Our ref: GON.0217.0126
Your ref: DC/21/1403v8
Planning ref: 2/2021/0275
Date: 08/11/2023

**RE: PROPOSED ERECTION OF 9 NEW DWELLINGS AND ASSOCIATED
WORKS AT LAND BEHIND THE DOG INN MARKET PLACE, LONGRIDGE
PR3 3RR**

We are writing to you in respect of the objection submitted by United Utilities (UU) with regards to the above planning application which requests further information in regards to drainage. The full objection is appended to this response and the pertinent points are summarised below:

Section along existing drain

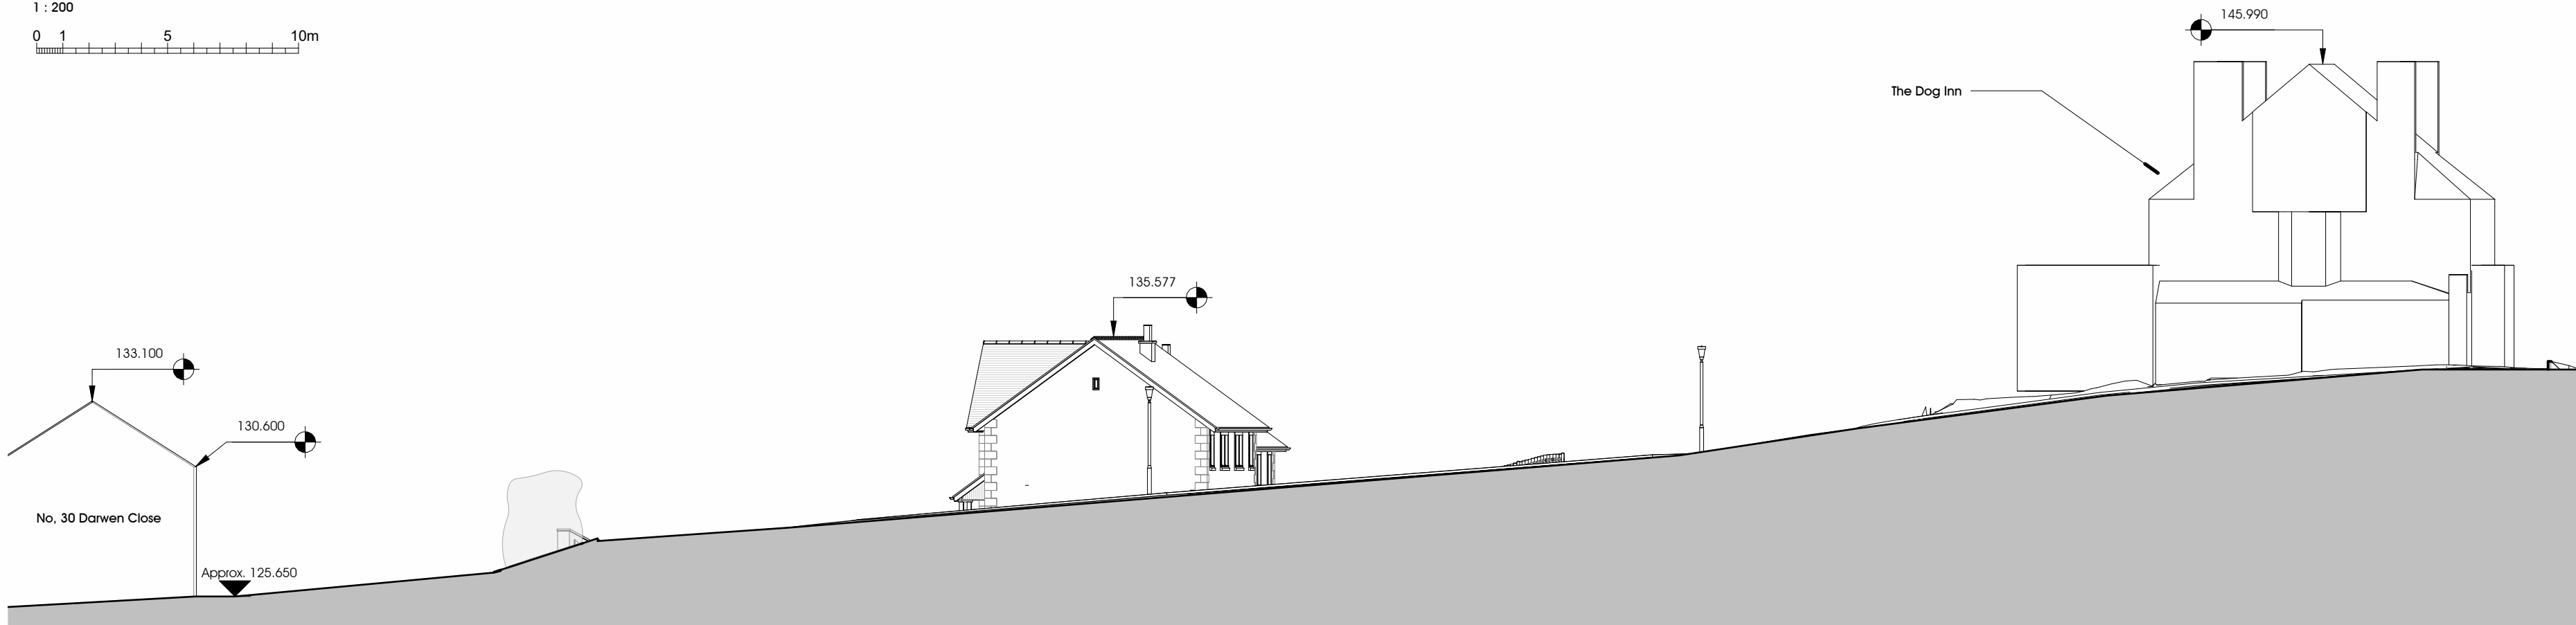
"We request that the applicant provides further information to confirm whether the existing public foul water sewer running through the site has been surveyed in its entirety to establish its accurate location especially as the proposed dwellings are located close by. It is requested the sewer is accurately located. "

"We request that the applicant confirms whether there are proposed changes to ground levels over or near to the existing public sewer. "

"We request that further information is provided regarding the location and details of any proposed retaining walls which are proposed over or near to the public sewer located within the site."

The client commissioned Lanes Group plc to undertake a CCTV survey of the public sewer within the site extents. The survey confirmed the route between manhole nodes 7202 and 6102. The route between manhole nodes 7202 and 7201 was partially surveyed from 7202 but was unable to be completed due to the presence of a backdrop. The survey extents confirmed the pipe runs to be straight and connected to the identified manholes as expected. This survey, in conjunction with the topographic survey undertaken (which recorded manhole locations) confirms the sewer route as shown in the submitted planning drawings to be in accordance with UU asset plans.

A 6 metre wide easement buffer has been provided along the route of the existing public sewer in which no changes in ground levels are proposed with the exception of minor reprofiling where surfacing is proposed.

No retaining walls are proposed over or near to the public sewer located within the site. Existing embankments within the site are being incorporated into the site design.
